Re: EP/136/11

I am writing to oppose the above outline plan.

I am writing to object to the proposed building of a two-storey detached house - Ref: as above.

BLOCK PLAN 1/500

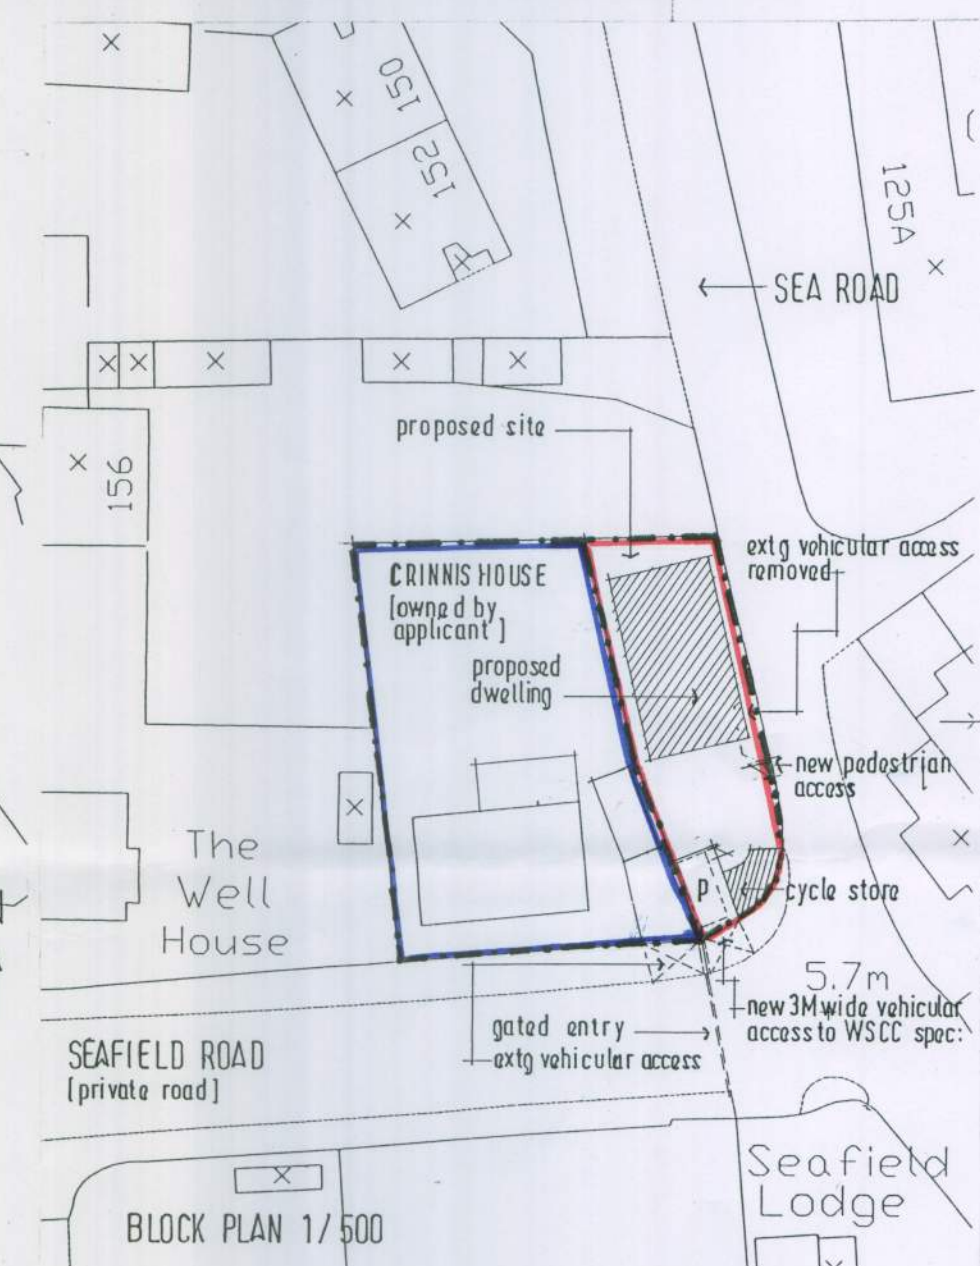
The proposed building will be extremely over-powering to my home and garden and would ruin the view I have now. It would also have a detrimental effect on the appearance and character of Sea Road. The property would appear cramped within the plot and the already substantial Crinnis would be left with minimal garden in comparison to its size. This property would have an adverse impact and cause unnecessary over dominance to the road and surrounding residents on land intended for garden space. A clear message from the recent 2012 quarterly East Preston newsletter was that "East Preston should remain a thriving garden village by the sea".

GROUND / SITE PLAN 1/100

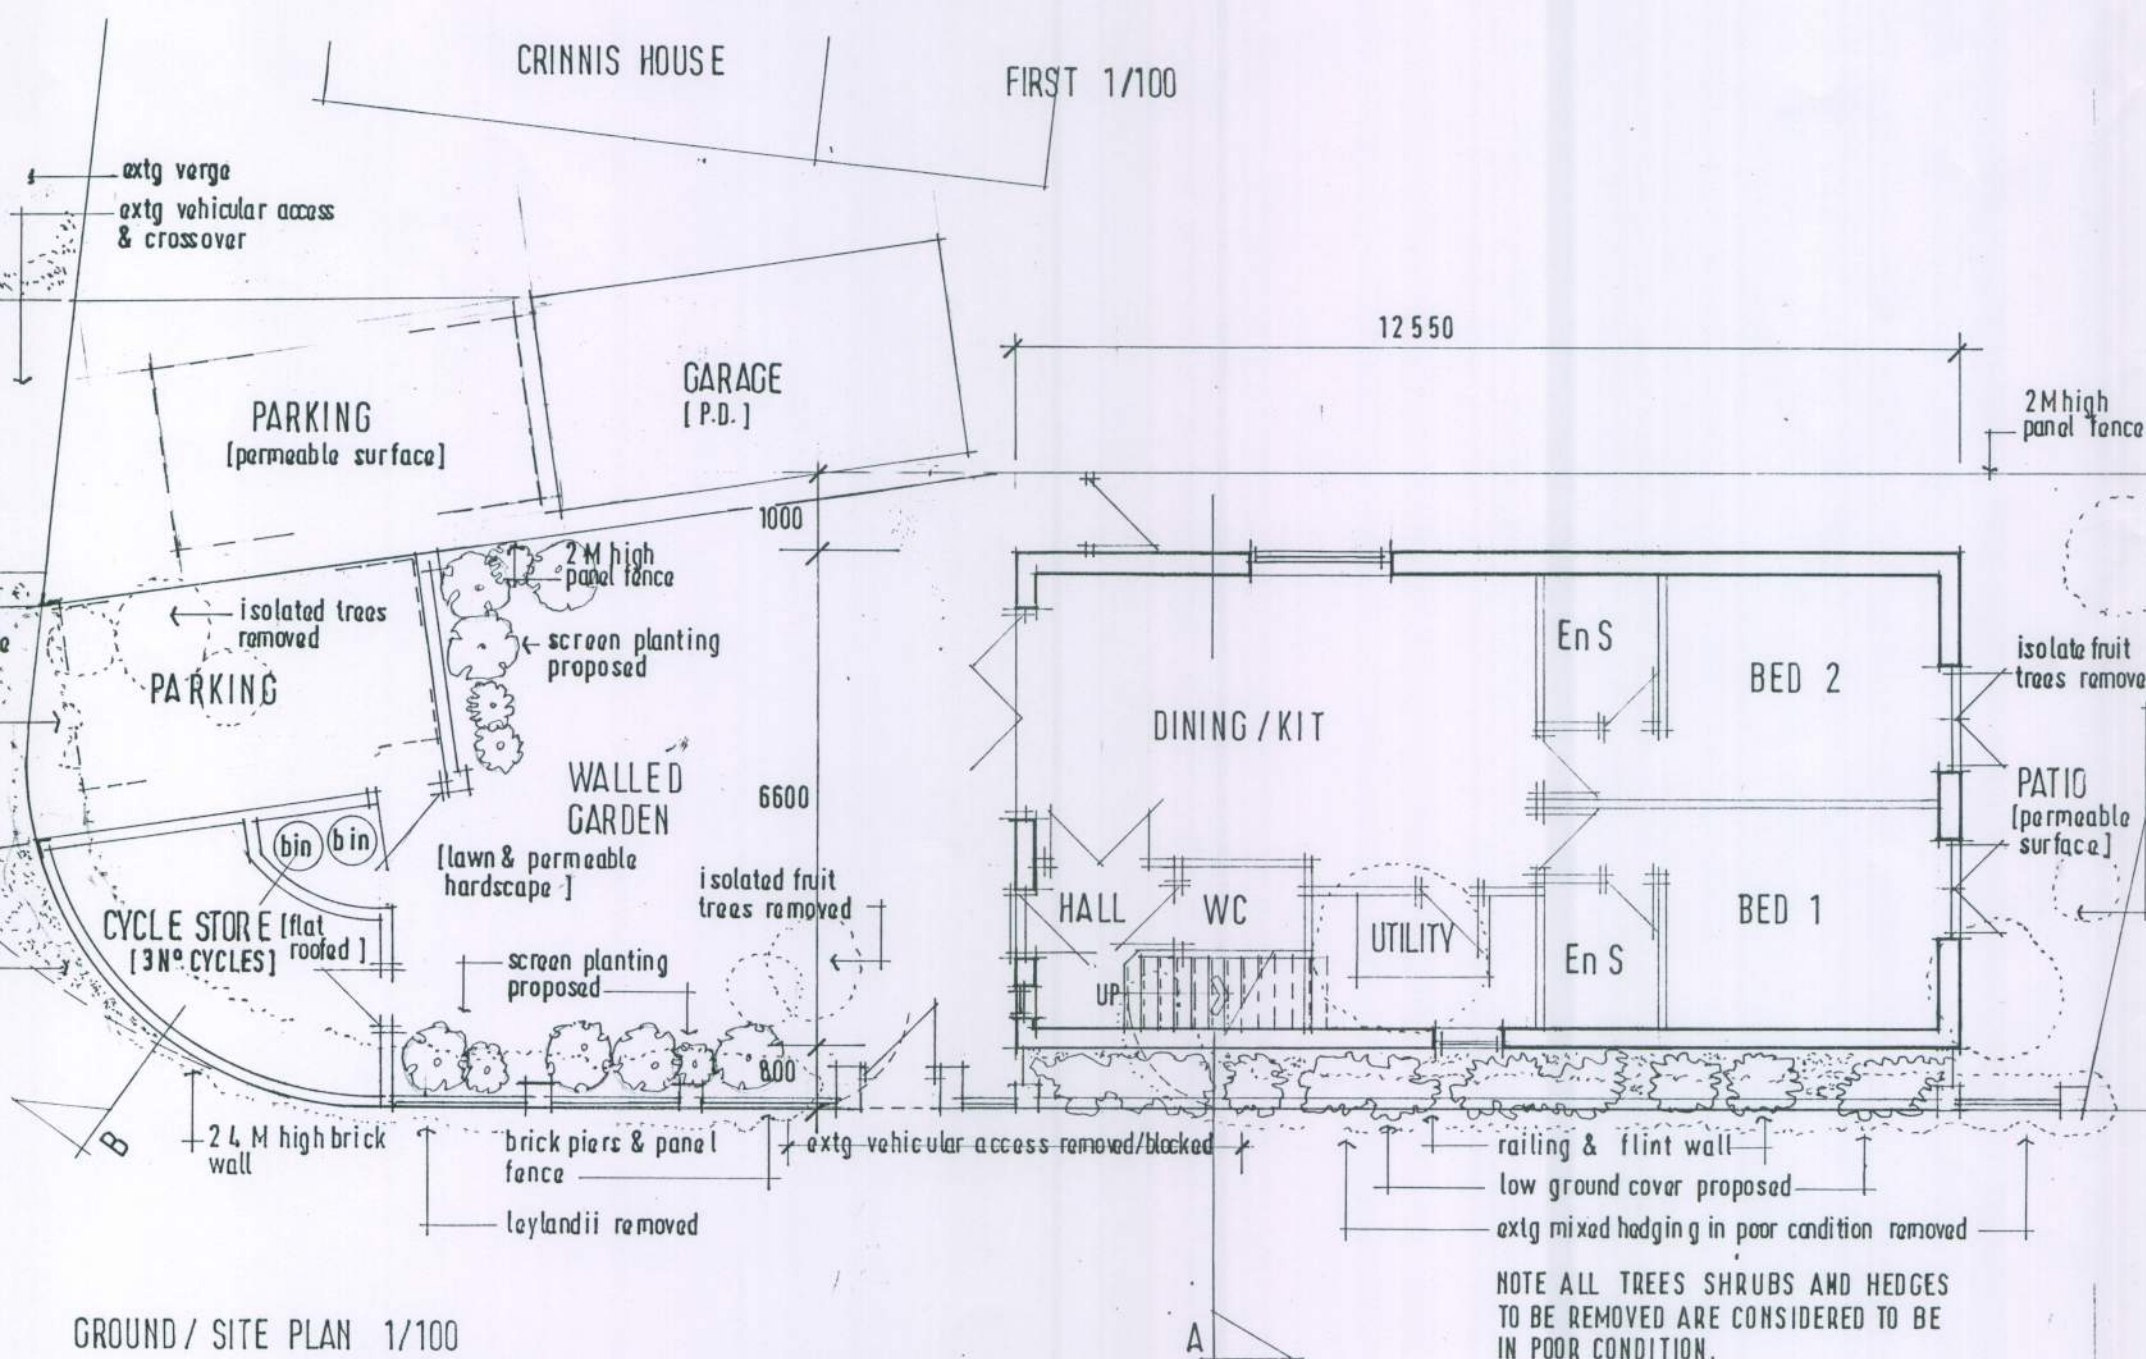
Initially I would like to draw attention to the fact that these plans make no mention of my home, **DENE COTTAGE, 156 SEA ROAD** as being the adjoining property to Crinnis. The garden at the front of my property is directly next to the boundary fence. Therefore the proposed property will border my garden. This is my only garden as there is no garden at the rear of the house.

- I would also like to add it is very unclear as to the exact position of the new property in relation to all the boundaries and measurements of the plot.
- No garage or street parking.
- Does this set an example to be followed? in other gardens.
